An
Coimisiún
Pleanála

Direction
ABP-321056-24

WHEREAS a question has arisen as to whether a change of use from ground floor public house with overhead residential to 3 bed residential unit at Georges Street, Gort, Co. Galway, and associated internal works is or is not development and is or is not exempted development:

CLIENT: CARLINE QUINN
 PROJECT: PROPOSED CHANGE OF USE @ STATION ROAD, GORT
 DRAWING TITLE: PLANS & ELEVATIONS OF PROPOSED DWELLING HOUSE

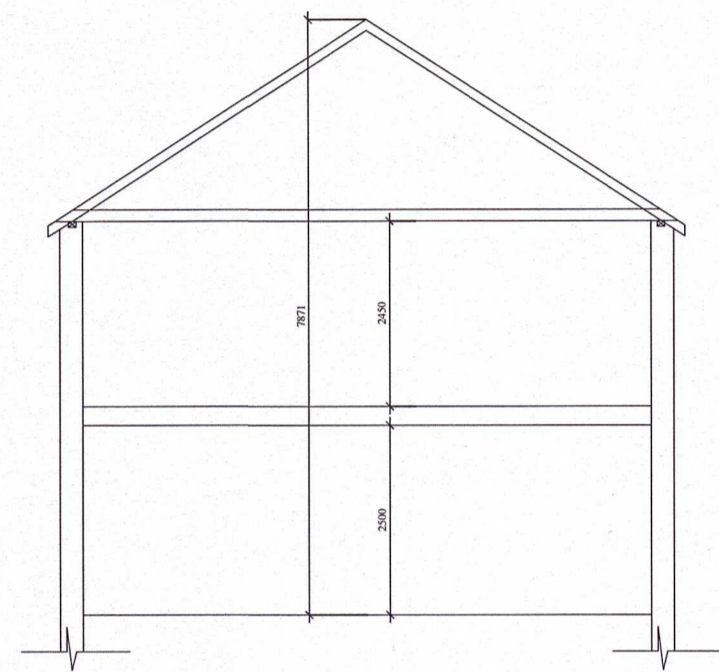
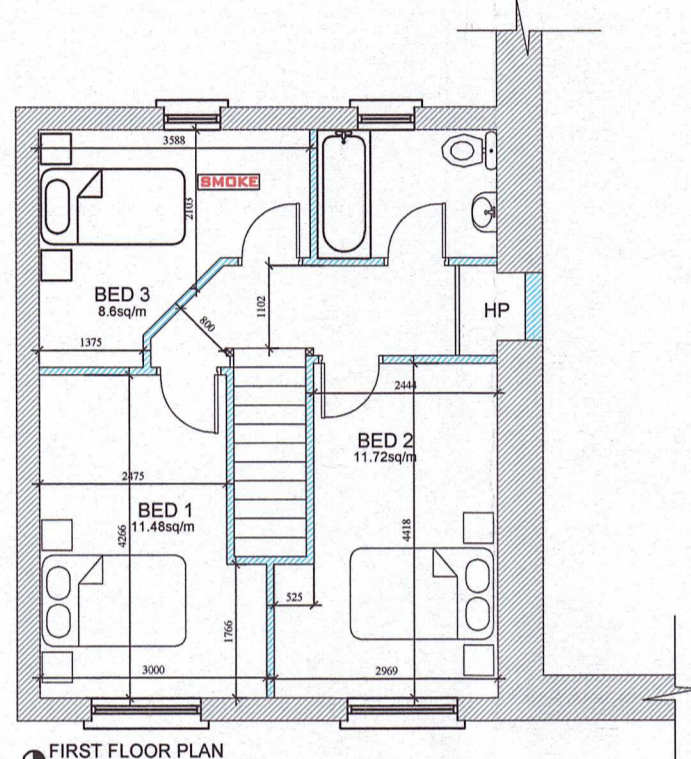
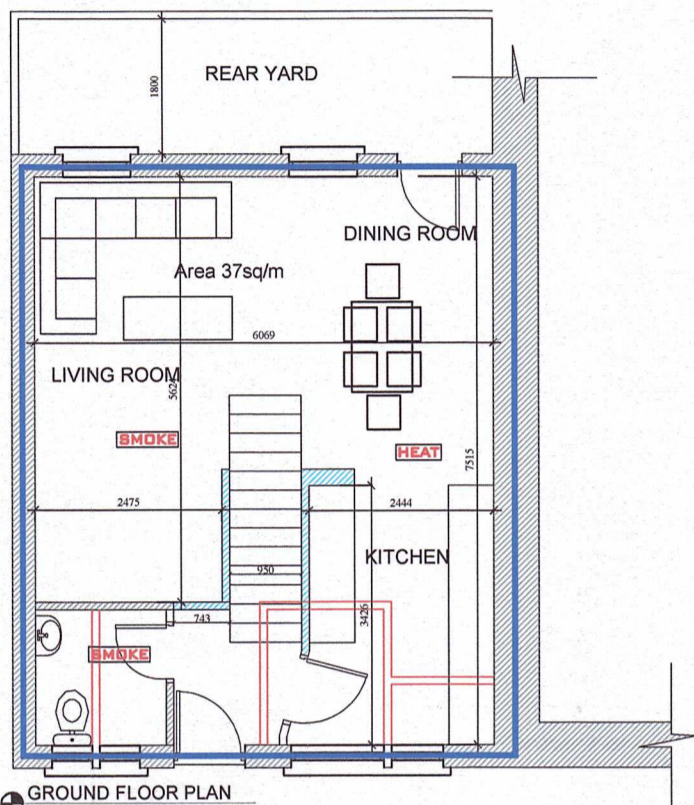
In any event, the restrictions on exemptions provided for in Articles 10(d)(vi) and 10(6)(d)(xi) of the Planning and Development Regulations 2001, (as amended), applies as the proposed residential unit would not provide storage spaces in compliance with the minimum storage requirements of the "Sustainable Urban Housing: Design Standards for New Apartments – Guidelines for Planning Authorities" issued under section 28 of the Act.
